Comments for Planning Application 24/00215/FUL

Application Number: 24/00215/FUL

Address: 15 Darwall Drive Ascot Berkshire SL5 8NB

Proposal: Section 73 application to vary conditions 02 (approved plans) 03 (Materials) & 04 (Windows and Rooflights) of planning permission 23/00426/FUL for the proposed part single storey, part two storey rear extensions, raising of the ridge height and loft conversion, garage conversion. (For clarification: this application seeks to improve aesthetics and be more in keeping with neighbouring properties).

PROPOSED LEFT HAND SIDE ELEVATION

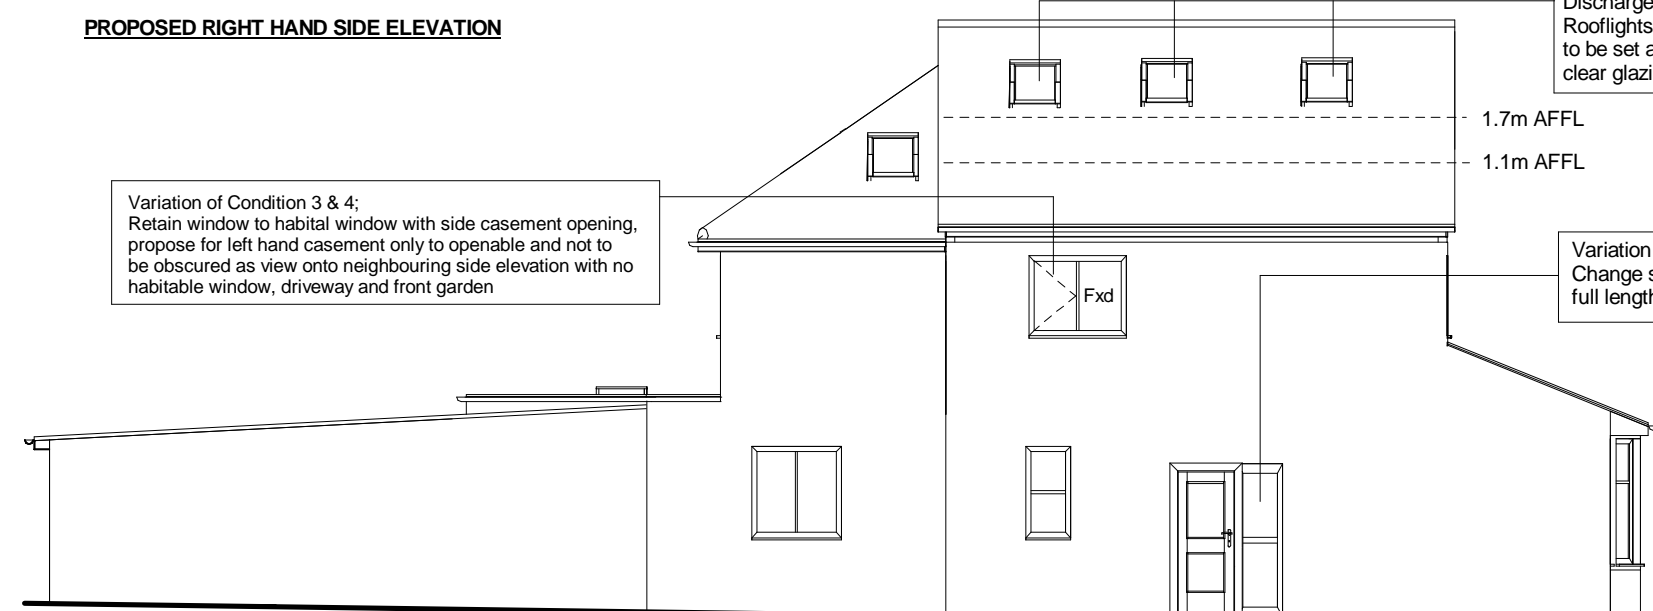
Comment: I object to any changes to windows on the 2nd floor. Any changes to windows on the 2nd floor would encroach on the privacy of neighbours. Although this would not necessarily affect my side, I feel if this is allowed it will set a precedent and an allowance for more changes. The applicants signed off on the original plans and agreed with the council that this is what they were going to follow. Nothing has changed so they knew the restrictions when it was signed off. This is already a very contentious build within the neighbourhood and I wouldn't want little changes to keep creeping in when all of the residents fought extremely hard against the planning permission in the first place. All of the concessions made were not satisfactory but the build was agreed nonetheless
